Grading and Erosion Control Plan_V1.pdf Markup Summary

Add PCD File # PPR-22-027

TEMPORARY EROSION CONTROL AND
SEDIMENT PLAN
DUNKIN BENT GRASS
SITE DEVELOPMENT PLAN
LOT 1A, BENT GRASS EAST COMMERCIAL FILING NO. 2A,
LOCATED IN TOWN OF PEYTON,
COUNTY OF EL PASO, STATE OF COLORADO

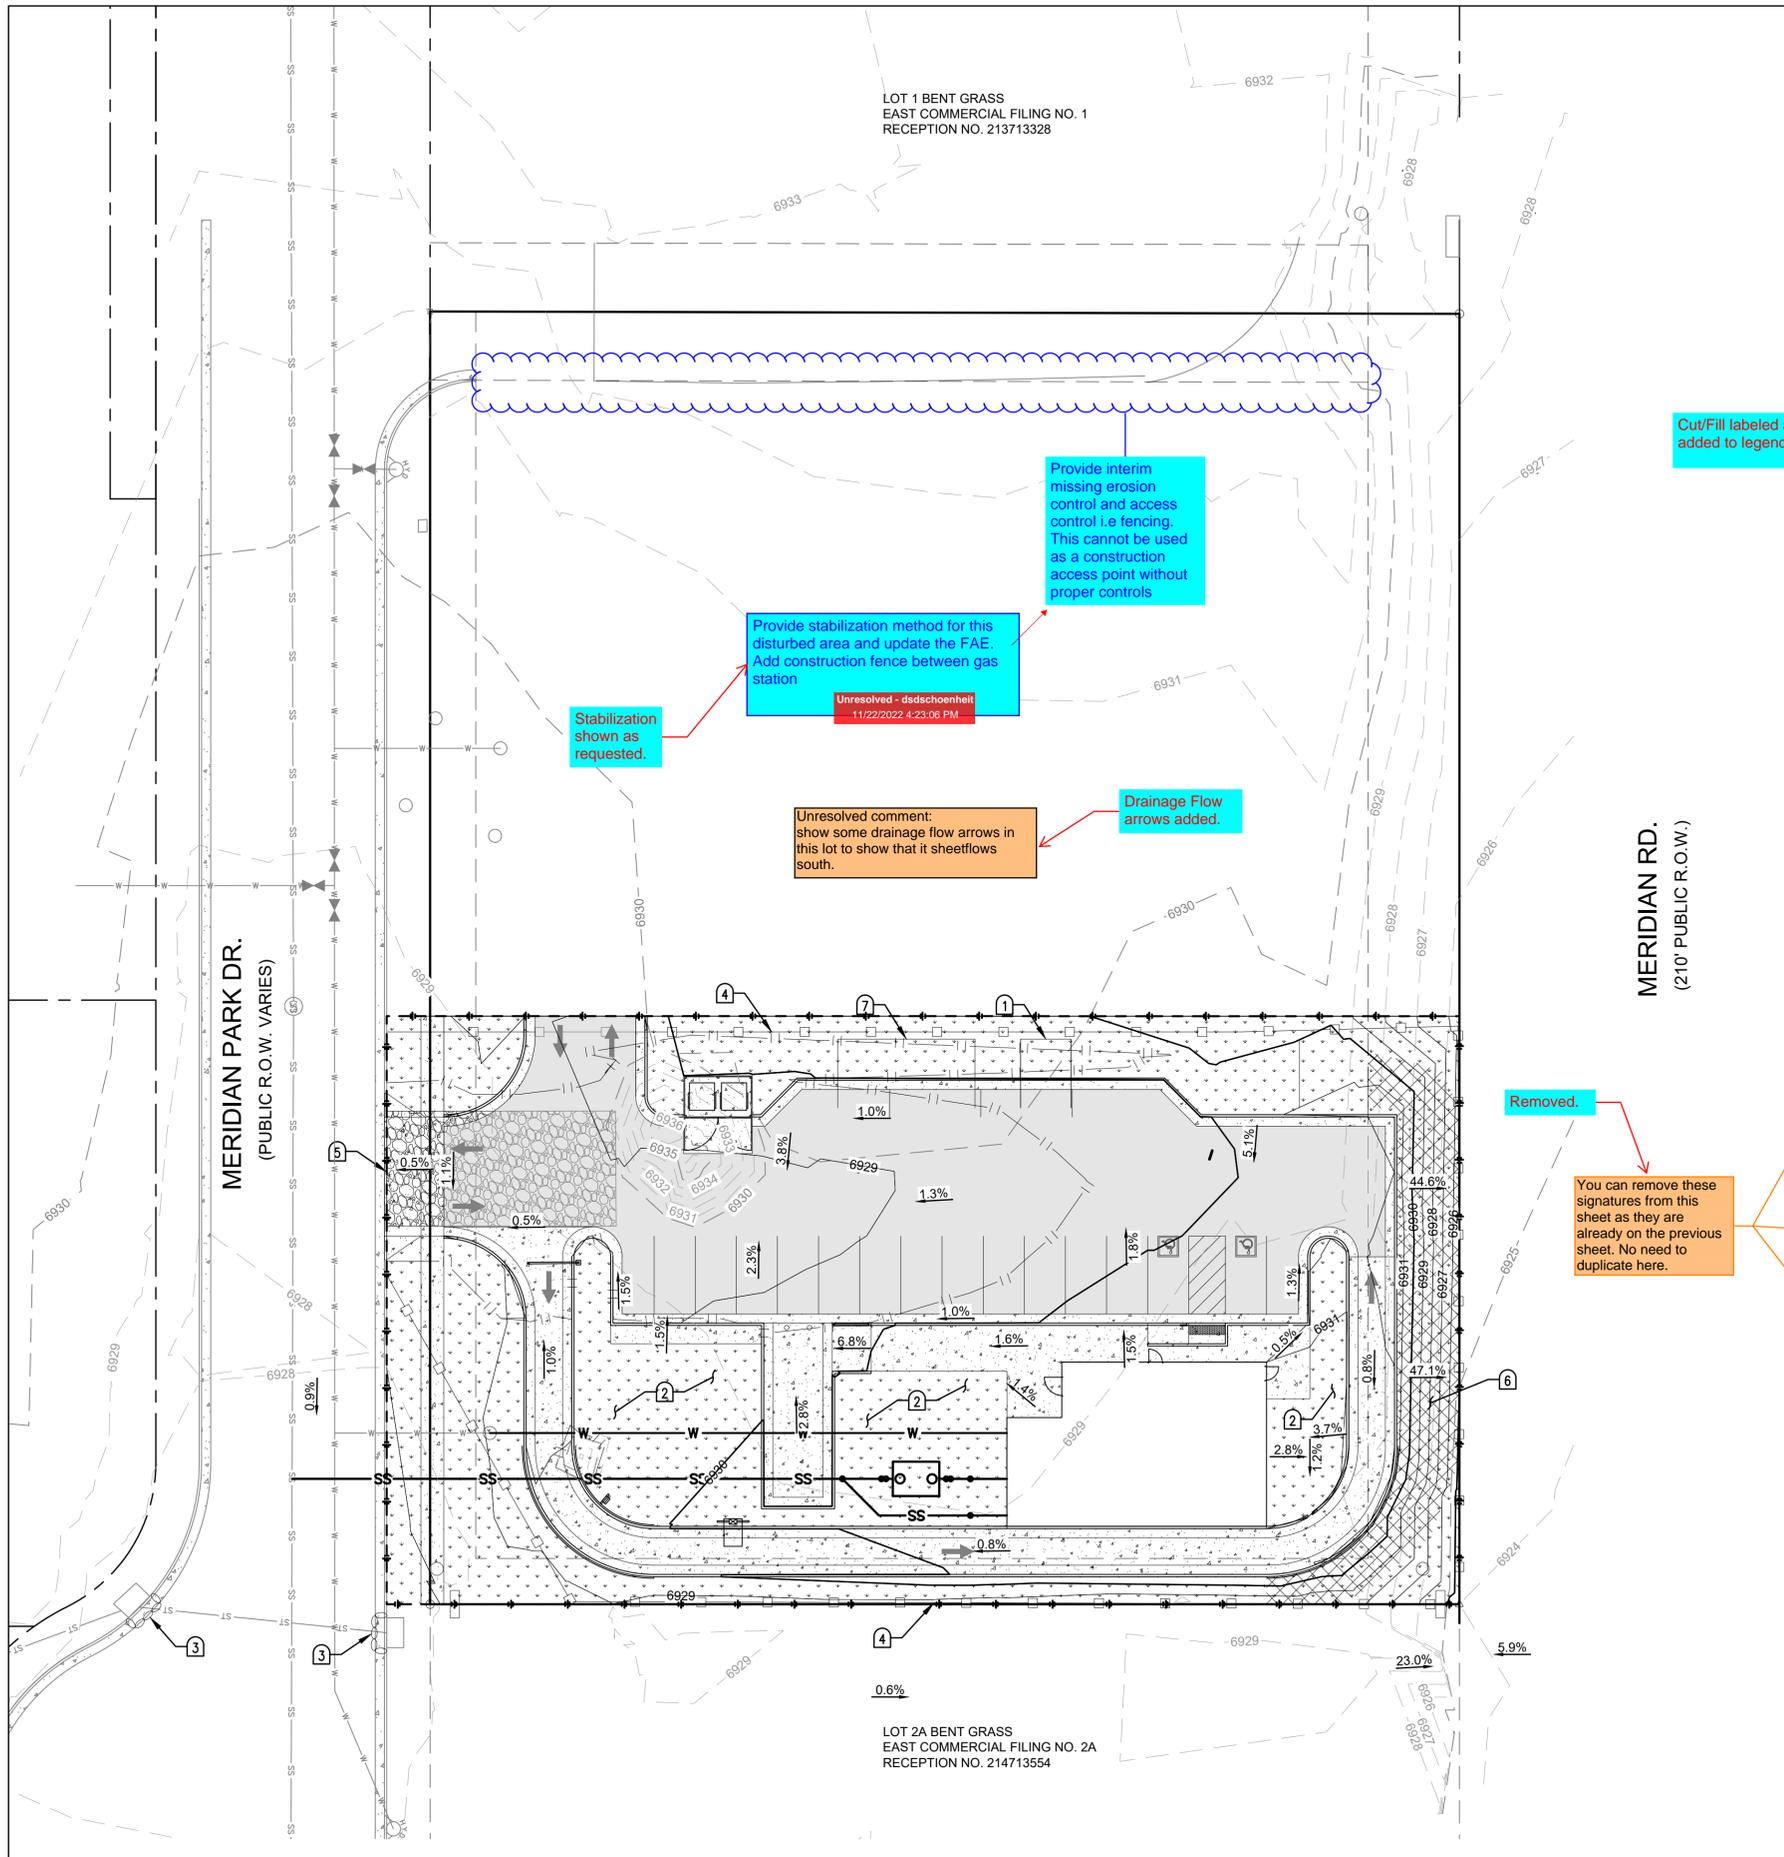
Standard EPC GEC notes and BMP std details need to be on the GEC plans. They are currently shown on the Site plan. Please move to GEC plans on additional sheets and remove from site plan.

Sheet 10 not included. Need to have these details included with the GEC Plans. Found them in the SDP. Remove from SDP and add to GEC Planset

GRADING & DRAINAGE PLAN

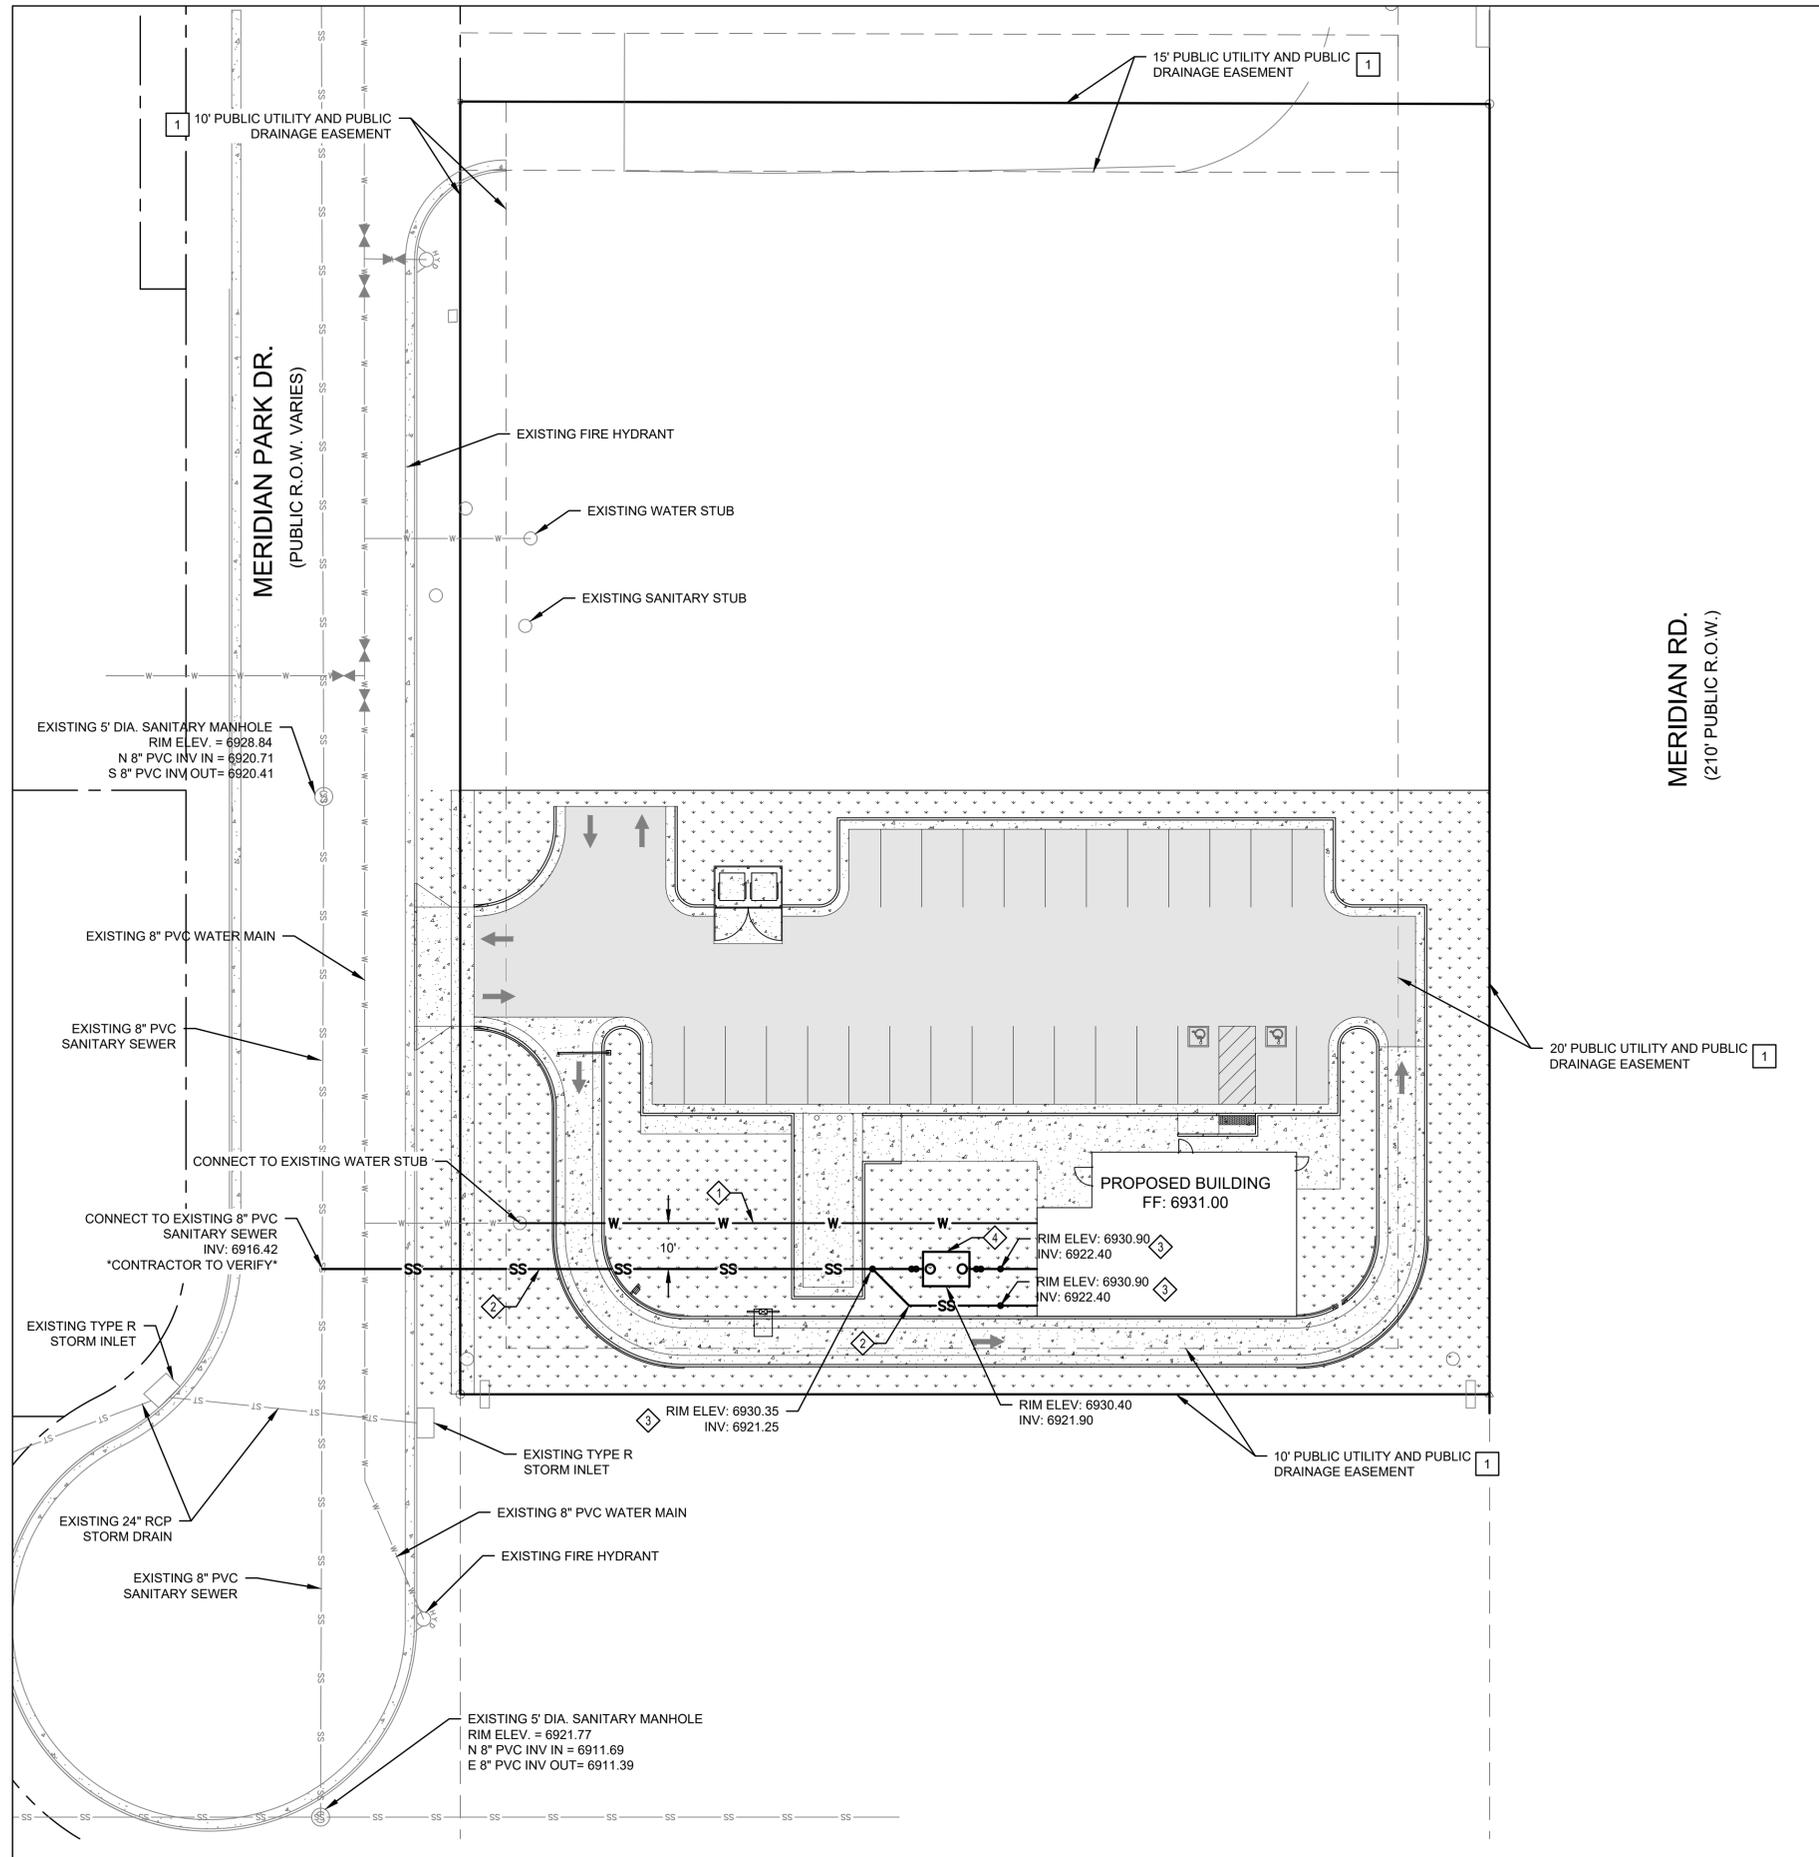
Add curb and gutter per drainage report

show some drainage flow arrows in this lot to show that it sheetflows south.
